**From:** Carol Reynolds <Carol.Reynolds@arun.gov.uk>  
**Sent:** 16 April 2021 11:48  
**To:** Michael Eastham <Michael.Eastham@arun.gov.uk>  
**Cc:** David Denham [REDACTED]  
**Subject:** A/39/21/DOC - Land South of Water Lane, Angmering

**Environmental Health:** I refer to the Acoustic Report/Sound Insulation Assessment, prepared by Meyer Brown, Project Code 24612, Version 1.2, March 2021.

**Application No:** A/39/21/DOC

**Description of Works:** Approval of details reserved by condition imposed under A/99/17/OUT relating to conditions 9- noise mitigation scheme, 16-details for decentralised & renewable low carbon energy sources & 17-Broadband speed.

Figure 2: Plots to Have System 3 (MEV) Ventilation

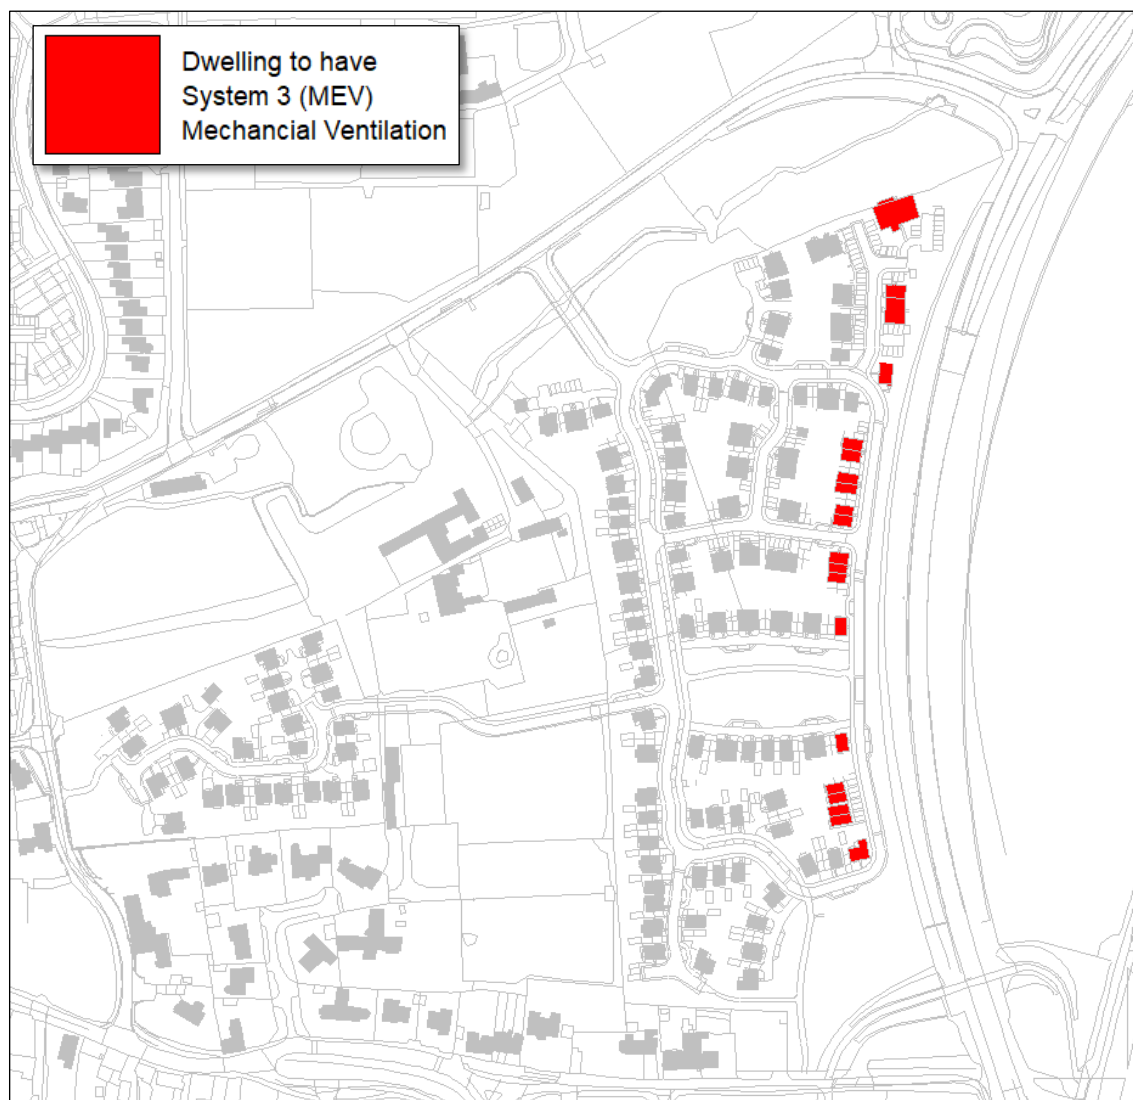
The report states that analysis was carried out of the 1 minute LA<sub>max,f</sub>, fast, at 2 positions where the corrected figures were found to be 73 LA<sub>max,f</sub> (A1, A280 south) and 72 LA<sub>max,f</sub> (A2, A280 north), although the meaning of 'the 10<sup>th</sup> highest individual event value,' used to determine these figures is not described. This level of LA<sub>max,f</sub> indicates a medium risk of potential for sleep disturbance and therefore the need for increased noise mitigation in the form of mechanical forced air ventilation to those houses/flats adjacent to the A280.

\*the outline of the 8 flats, 159 to 167 (actually 160 – 167) does not accord with the outline of the room layout plan. The second floor (not described) is presumed to have the same noise exposure as the first floor.

\* Flats 174 to 175 – does not show that the longer 'stairs' façade will face the A280, in which case bedrooms on the opposite flank would be protected from road noise

\* Flats 168-169 and 170 – 173 should be included in this Appendix at least in that the orientation of habitable rooms should be described

\* Plot 72 – Will this drawing will be reversed so that the longest façade, including bedrooms, will face the A280
